Application No: BR/94/22/HH
Site Address: 38 Bassett Road Bognor Regis PO21 2JH
Description of works: Roof extension to create 2 additional annex including the installation of 4 x dormers and balcony and alterations to fenestration/openings.

Thank you for your internet representation made on 30th May 2022 which has been recorded as an objection with the comments as follows:

Proposed First Floor Plan

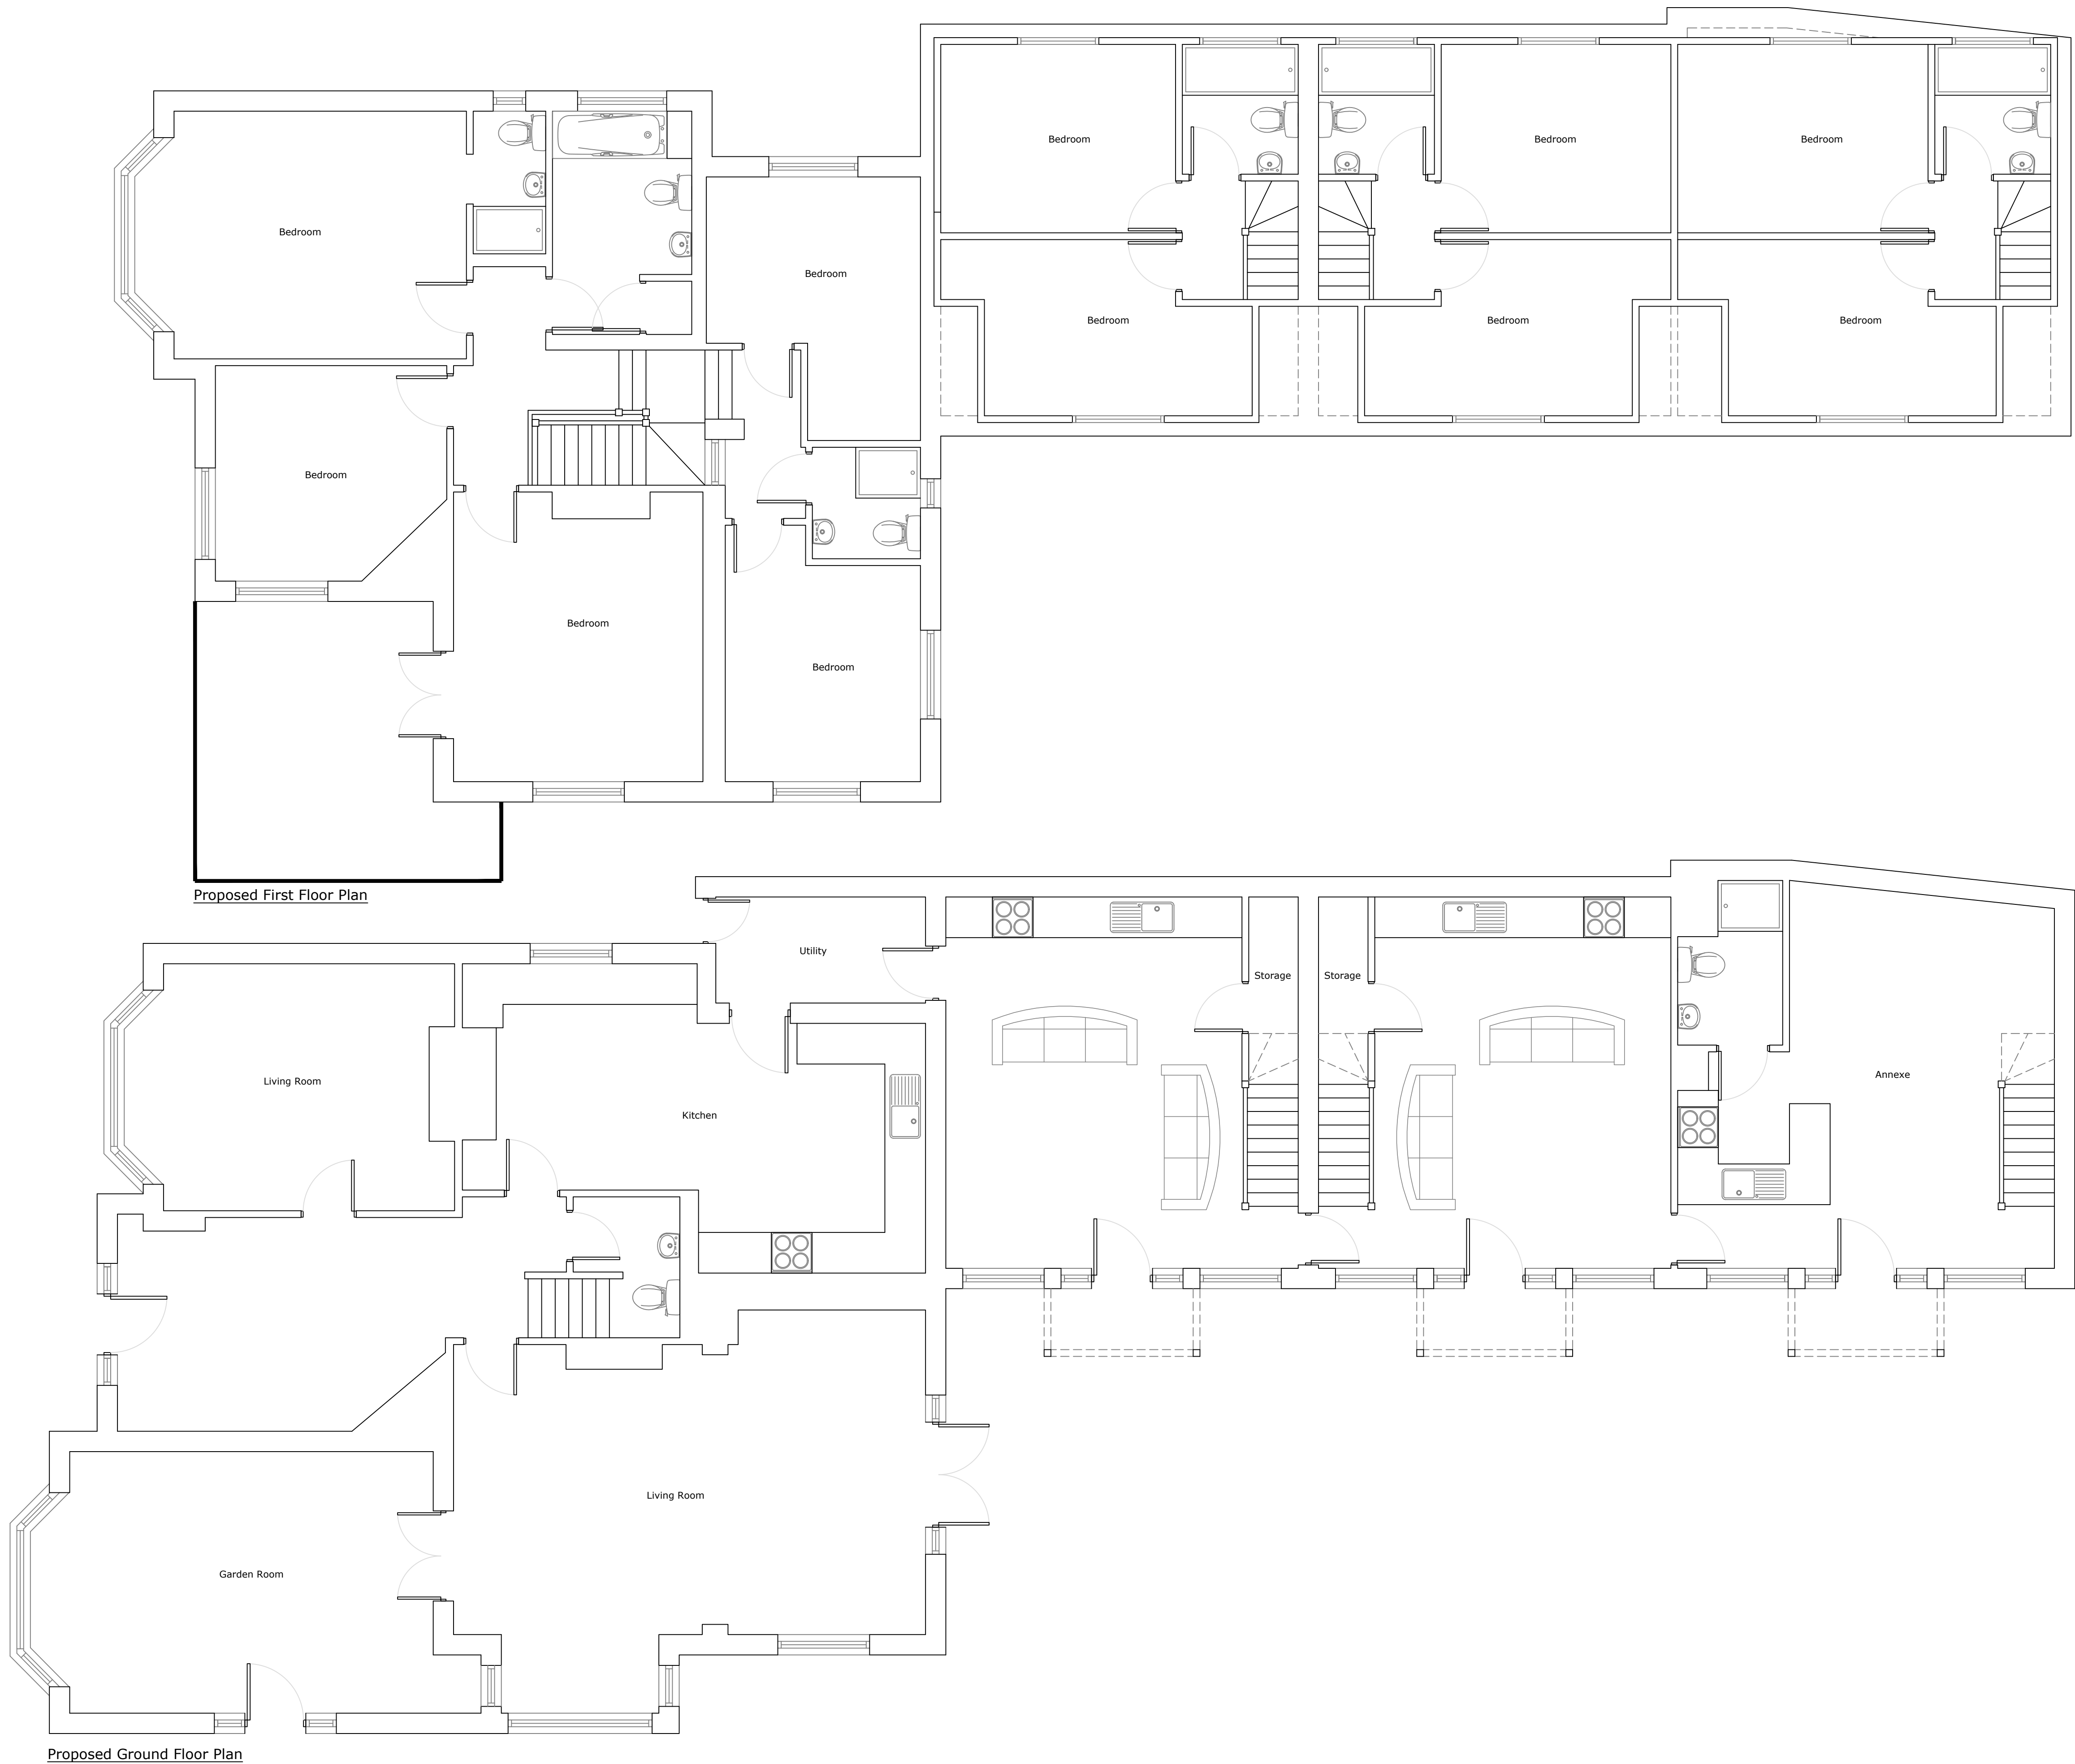
HI I FEEL THE PLANNING EXTENSION TO INCLUDE 3 DWELLINGS IS COMPLETELY UNSUITABLE AS THEY WILL INFRINGE ON OUR PRIVACY 6 WINDOWS OVERLOOKING OUR GARDEN (6). PLUS THEY ARE ALSO OUT OF CHARACTER WITH EXISTING PROPERTIES. WILL IMPACT ON STREET PARKING MANY THANKS KEITH
